CITY OF ALBUQUERQUE

**Re: Lobo Crossing
Traffic Impact Study (L15D051)**
Submittal dated May 12, 2025
Via email cgarcia@bowman.com and ABQ-PLAN
TRANS-2025-00136

The Traffic Impact Study (Study) received on May 12, 2025, has been reviewed by the City of Albuquerque Planning Development Transportation Section and has the following comments.

PEAK HOUR VOLUME SIGNAL WARRANT ANALYSIS

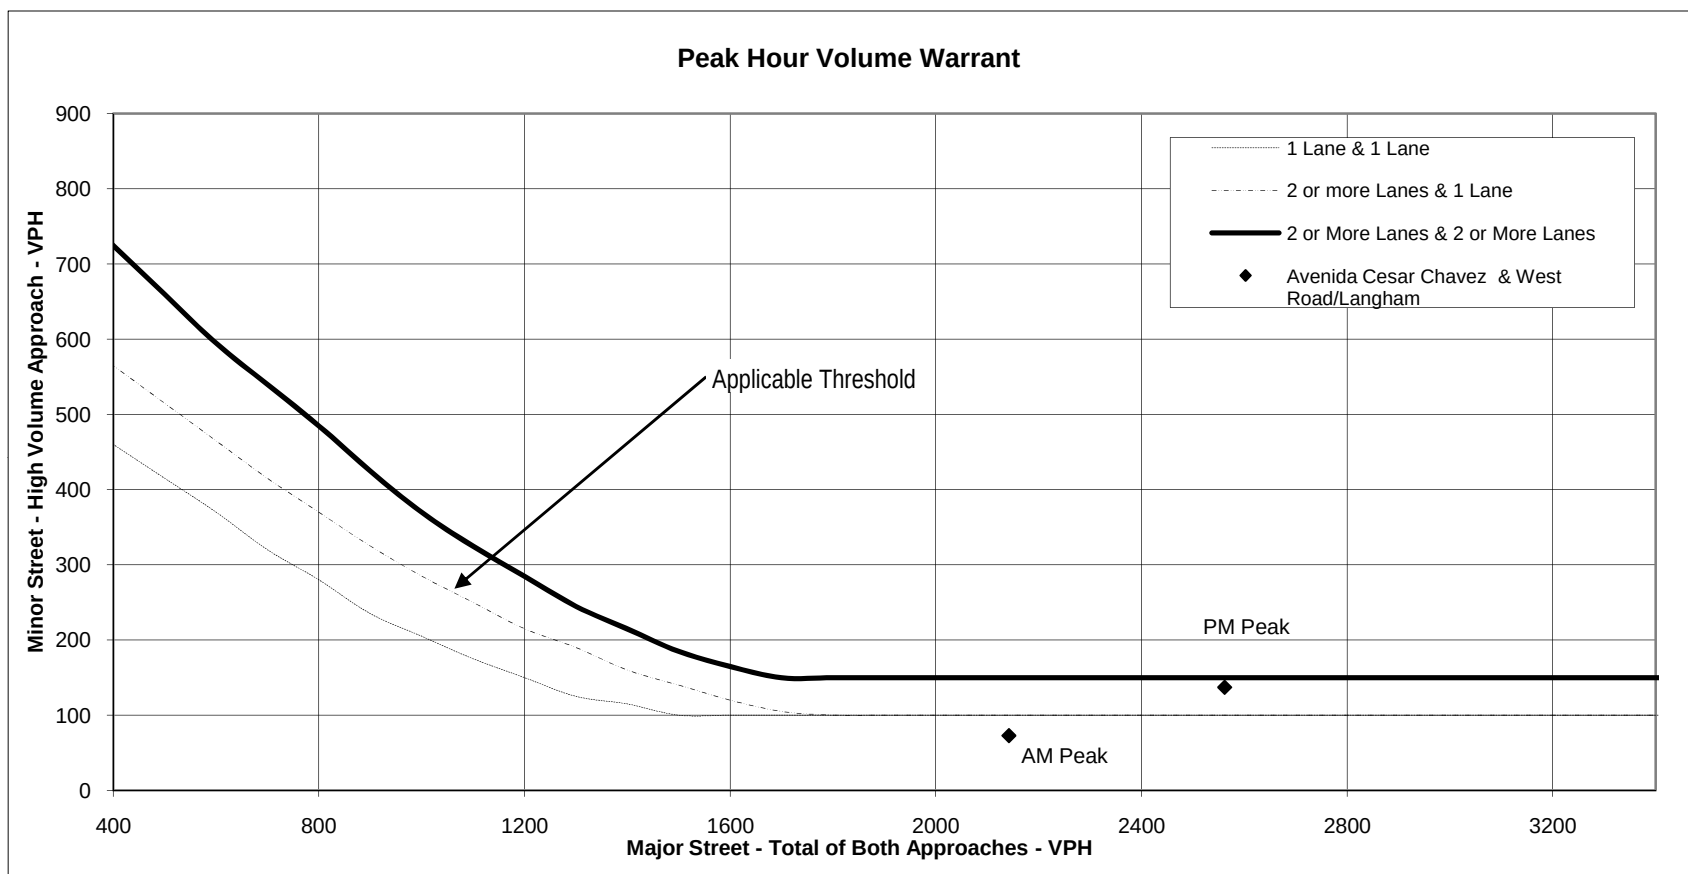
1. Please provide a narrative as to why no signal is recommended for Avenida Cesar Chavez/West Road/Langham Road intersection even though the warranting study shows that it meets conditions.
2. Please provide more detailed explanation as to why there are no mitigations for several movements with LOS F in the build condition.
3. Please address all comments provided by NMDOT, as the City typically withholds final approval until NMDOT is satisfied with the report.
